PLANNING AMENDMENT

H14/1180/97

PROPOSED SUBSIDISED HOUSING

Amendment: Add lay-by parking, shrubbery at access, fence/wall &
access to field (Dwg. No 2747-3 Rev A & 2747 Rev A)

scale	AS SHOWN	drawing no.	2747-3
date	NOV 97	drawn	
		checked

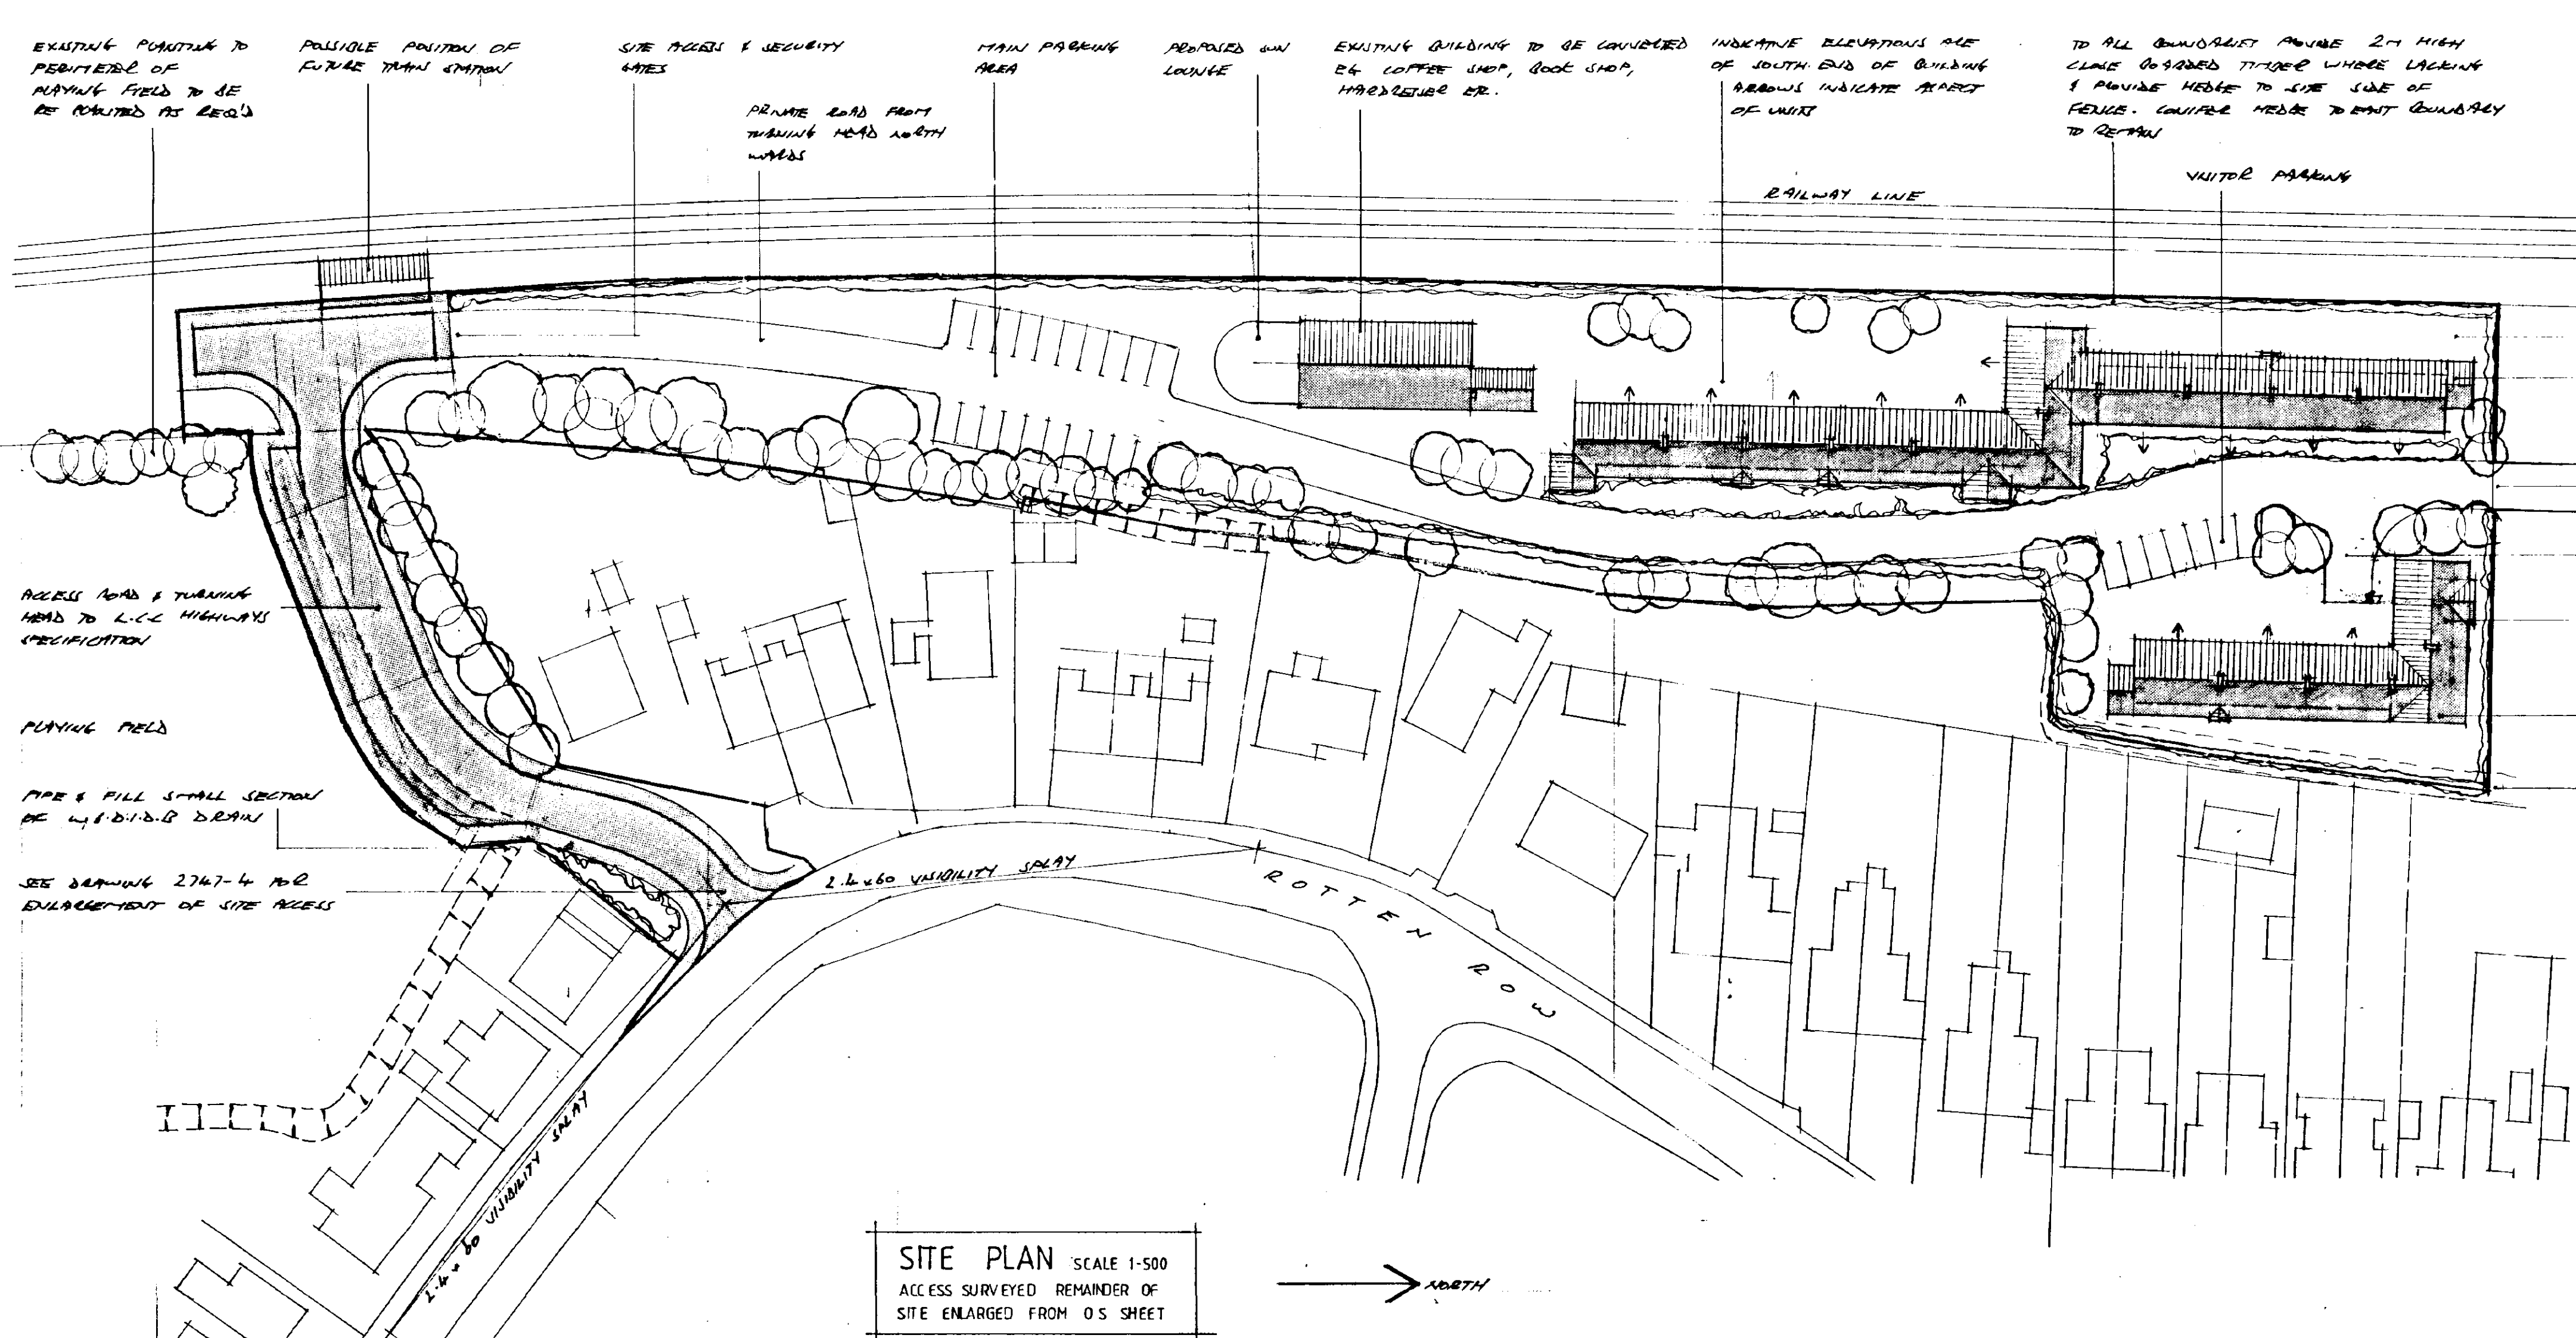
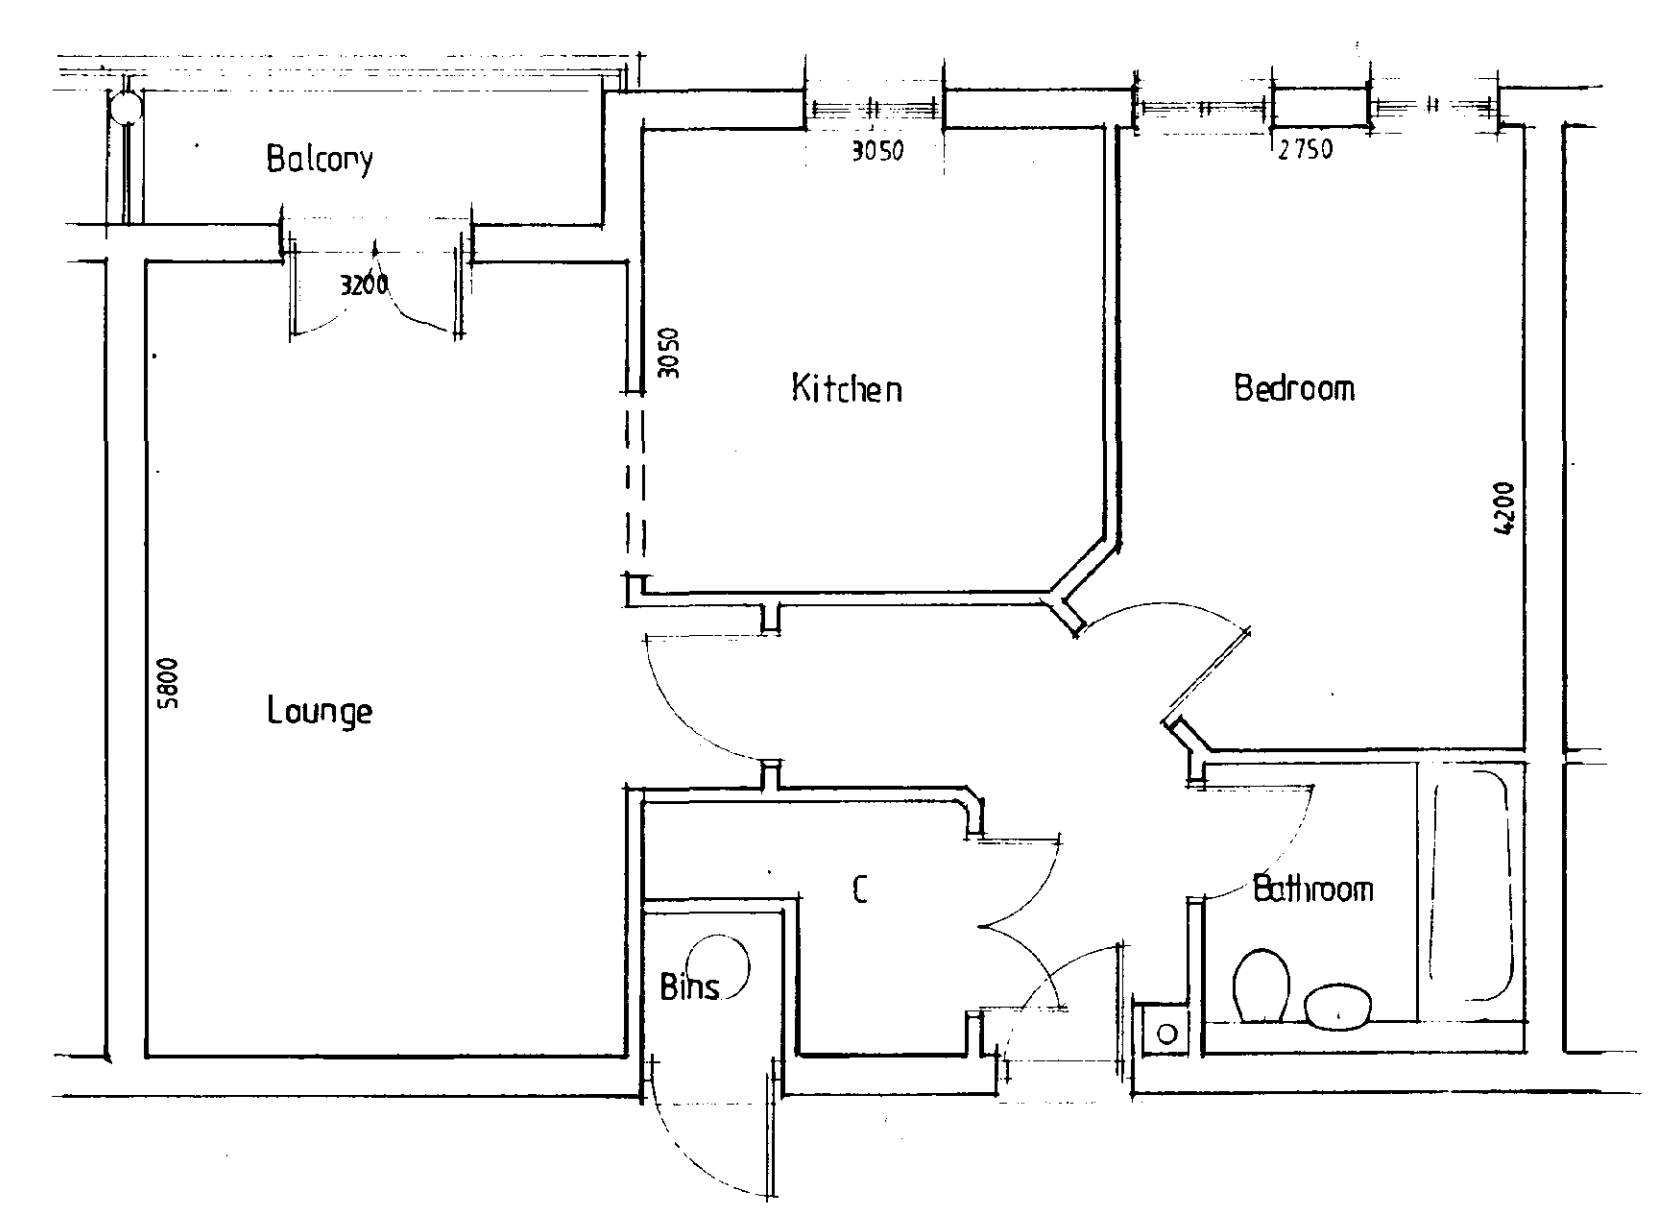
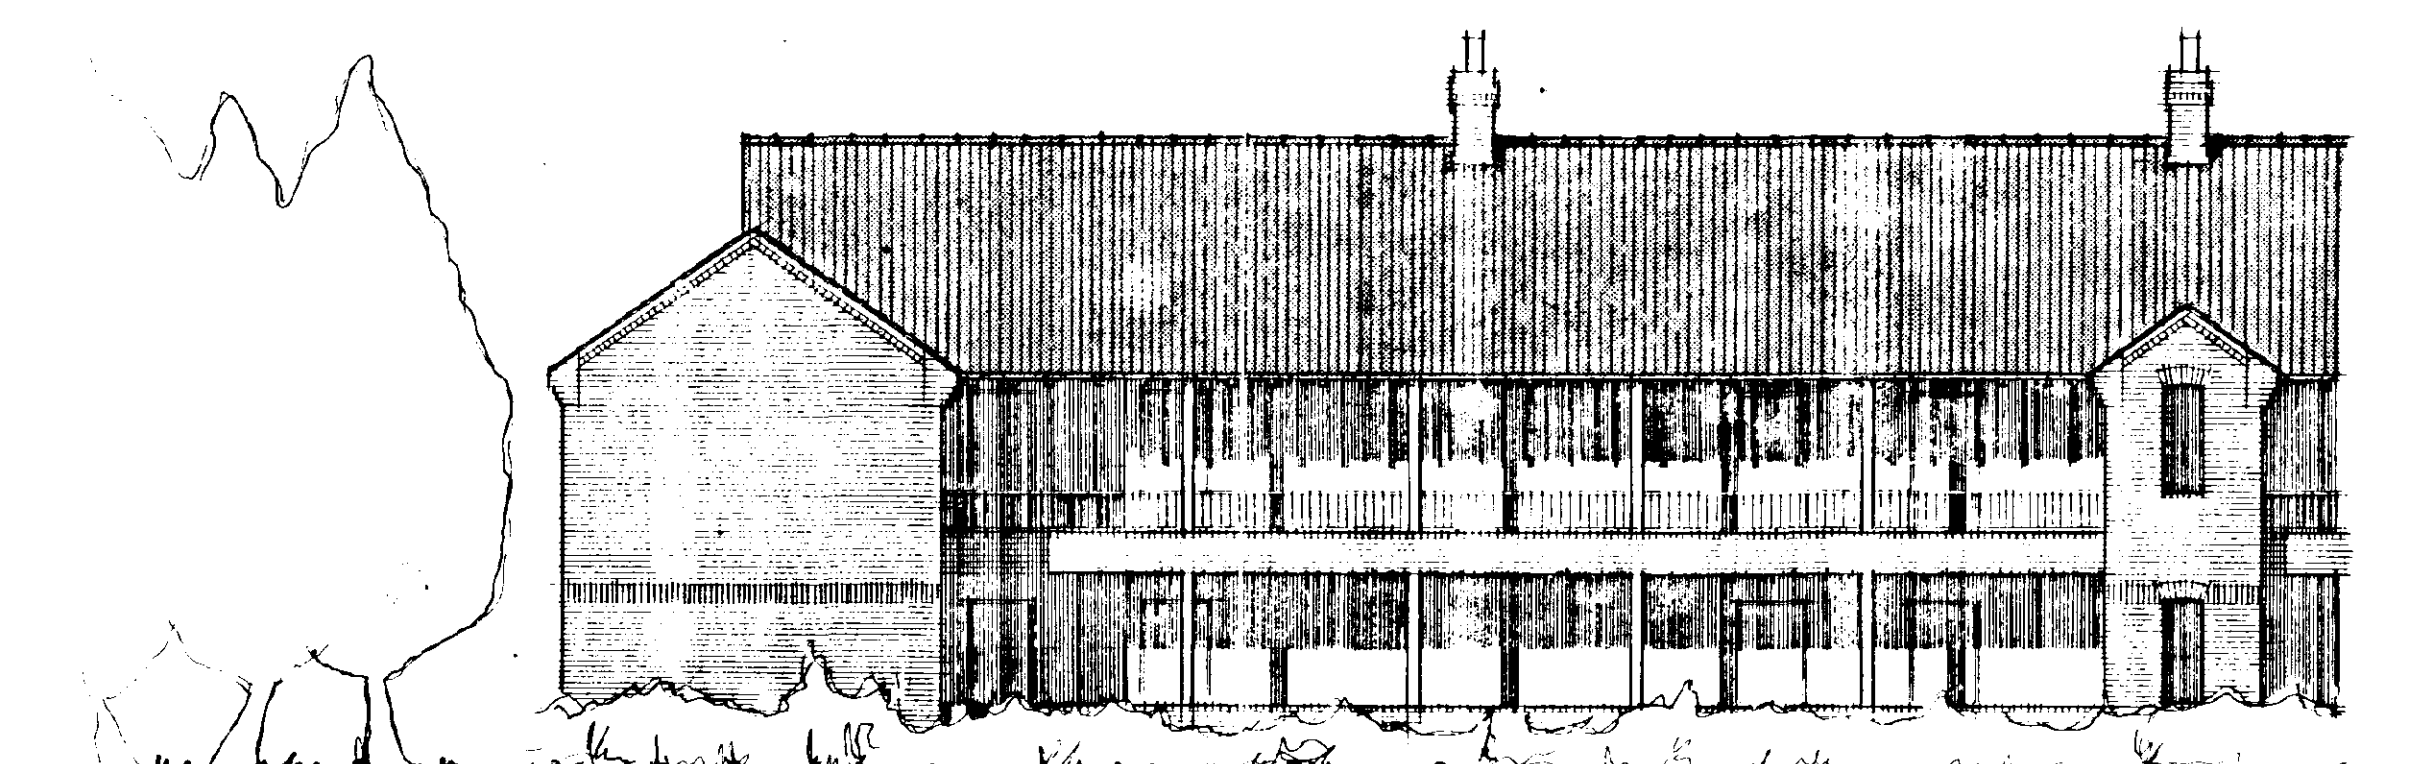
ADD 197-27 DALLING
- SHAMBHET AT REELS
- FENCE/WALL
- TREES TO FIELD
